**Lancashire
Constabulary**
police and communities together

25th February 2013

Outline Application 3/2013/0137 for up to 260 dwellings, primary school, vehicle link to A671, car parking and open space, Whalley.

Site: Illustrative Masterplan

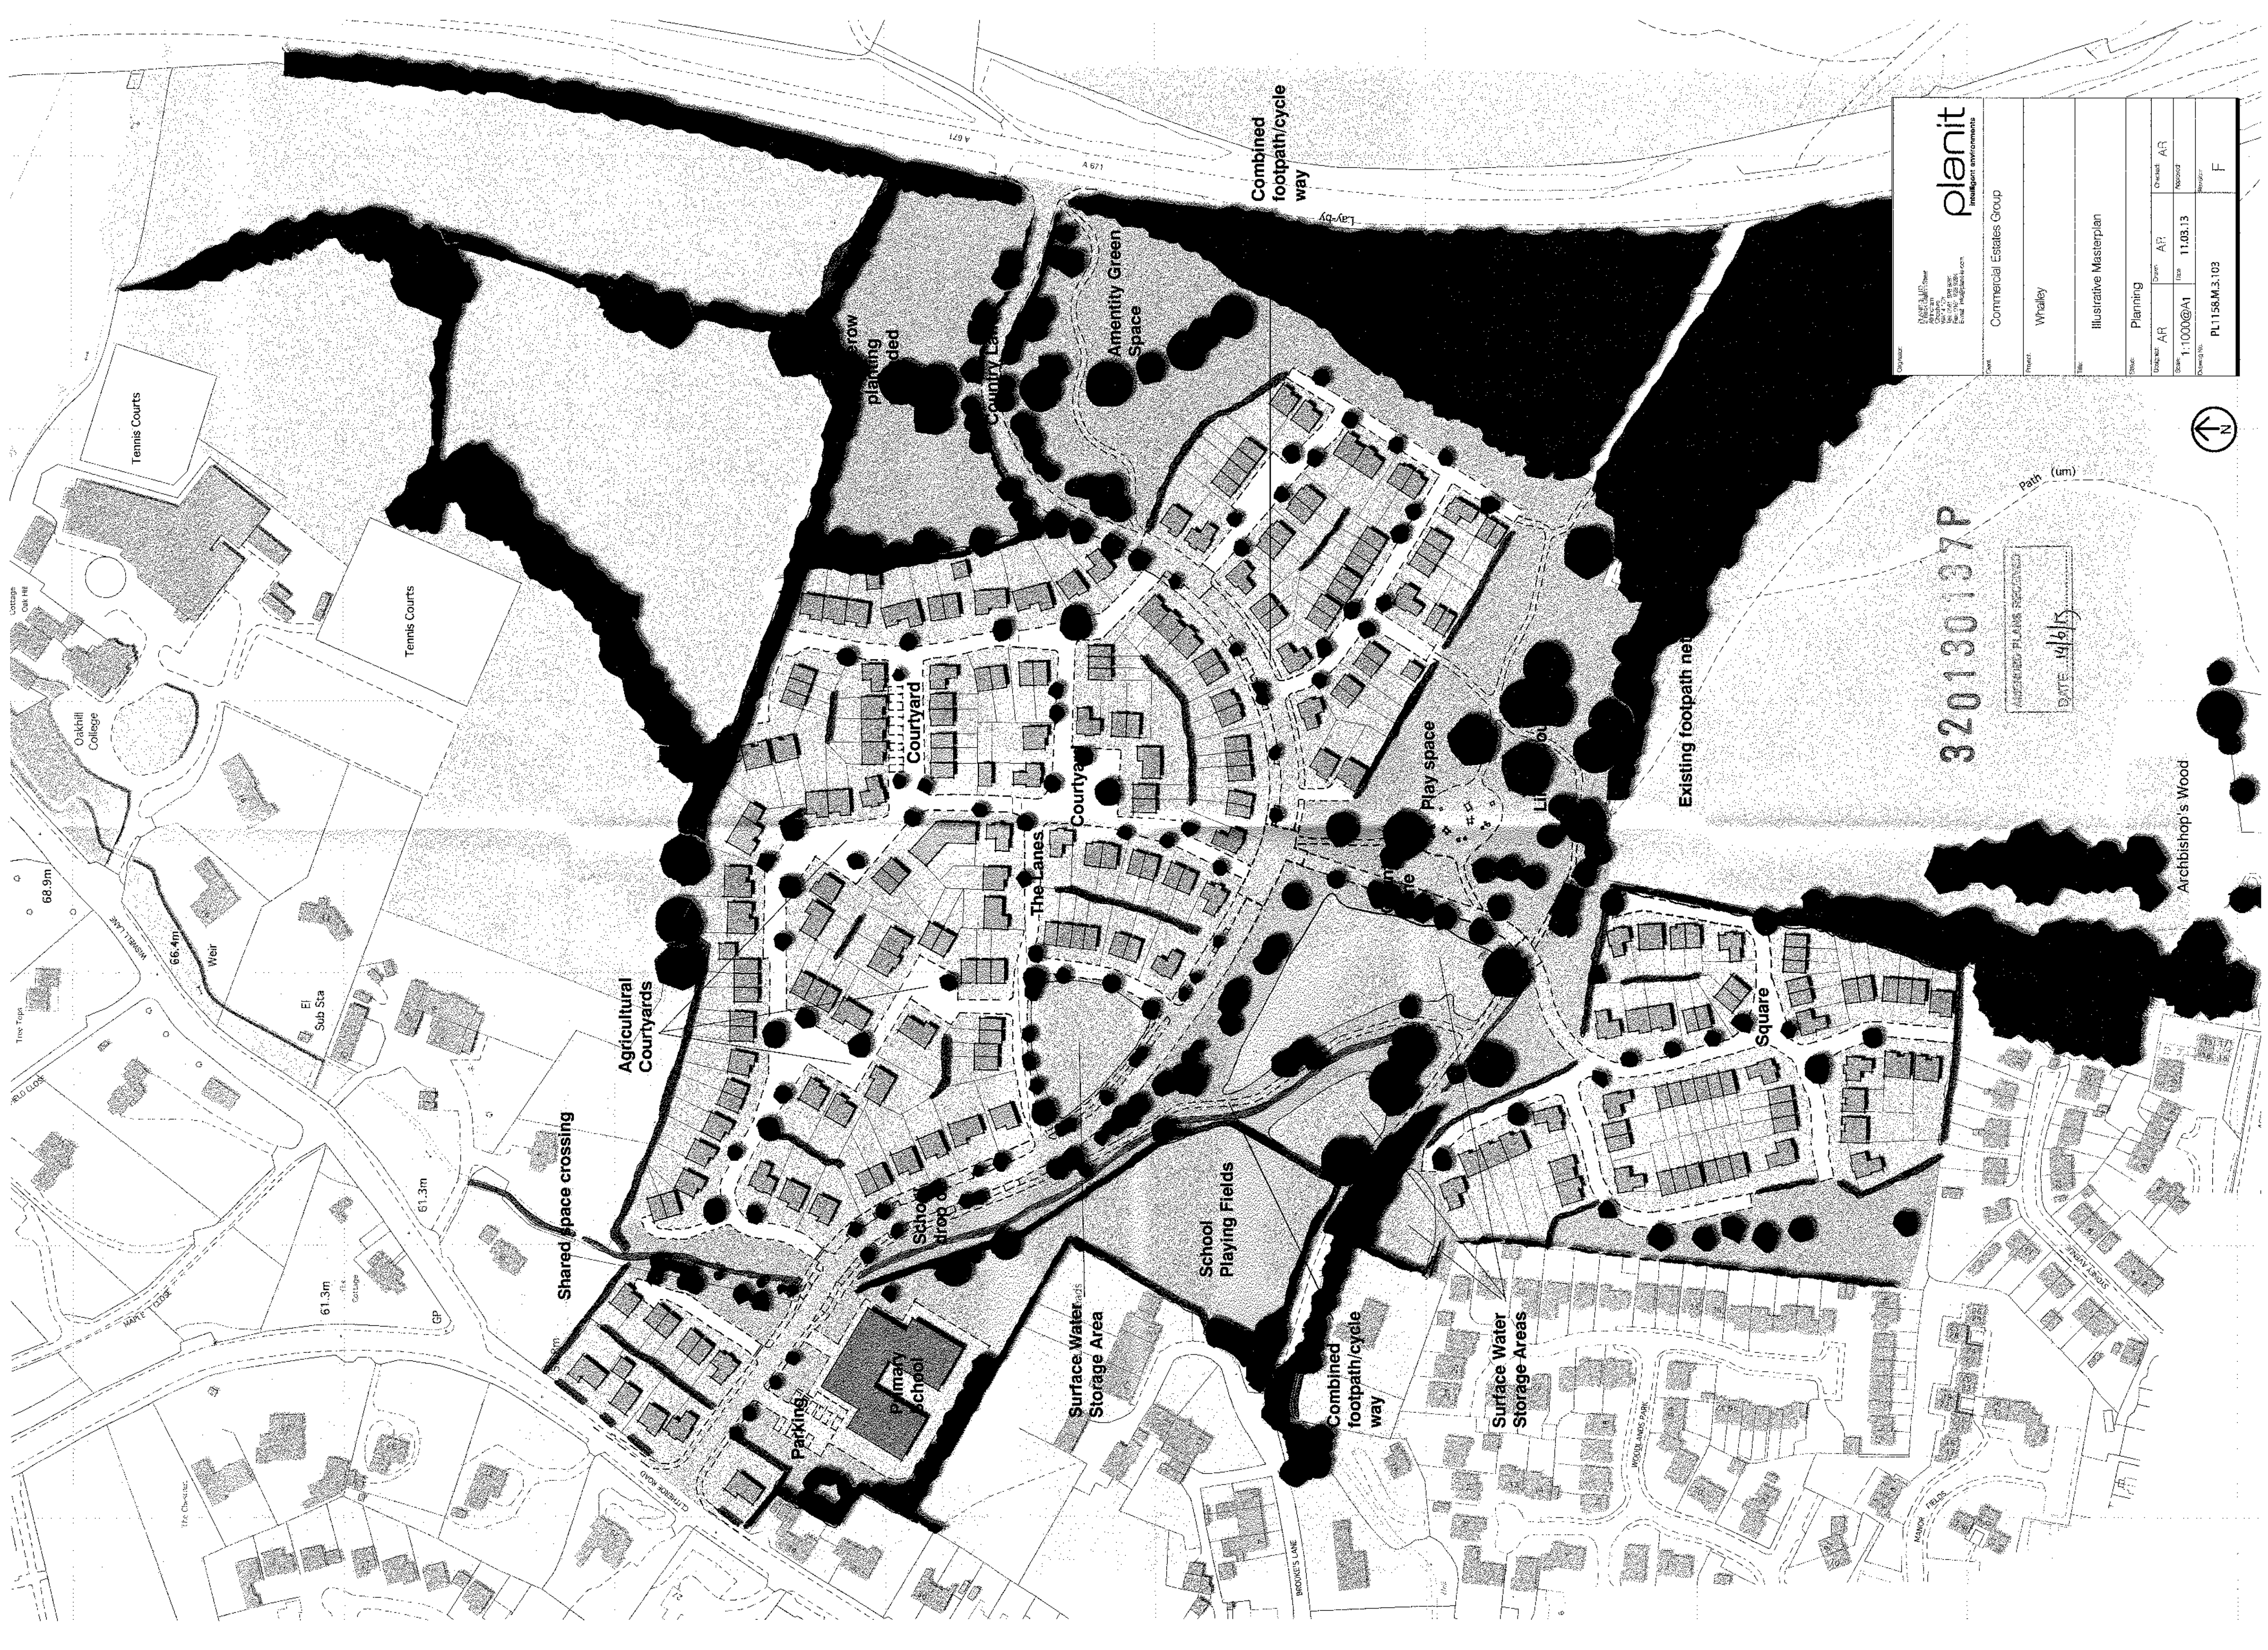
- ❖ I have grave concerns over the shared street area adjacent to the primary school where young children will be traversing on a very regular basis. A defined footpath is essential in such areas to ensure the safe passage of children who are told that the footpath is a safe place to walk. Omitting a clearly defined footpath from this area encourages children to use the whole space to walk, cross, run to meet their friends etc. Where they are expected to share this space with vehicles, the risk of a road traffic collision is significantly increased. I ask that consultation is undertaken with Lancashire County Council Highways, to discuss this specific part of the design.
Parking spaces that fall within the curtilage of the dwelling would be advisable here, and a separate area for parents to park when taking children to/from school, so that on street parking is minimised and a child crossing is less likely to take a driver by surprise.

- ❖ Any external furniture such as seating in the Brookes Lane courtyard area should be well overlooked from surrounding properties. These areas are likely to be used in the evenings for youths to congregate and behaviour can soon deteriorate, leading to damage and nuisance, when there is little chance of being observed.

- ❖ The lighting and landscaping designs should work together so that in areas where both sit side by side, such as the grass verge where the housing overlooks the open space, one doesn't obscure the other.
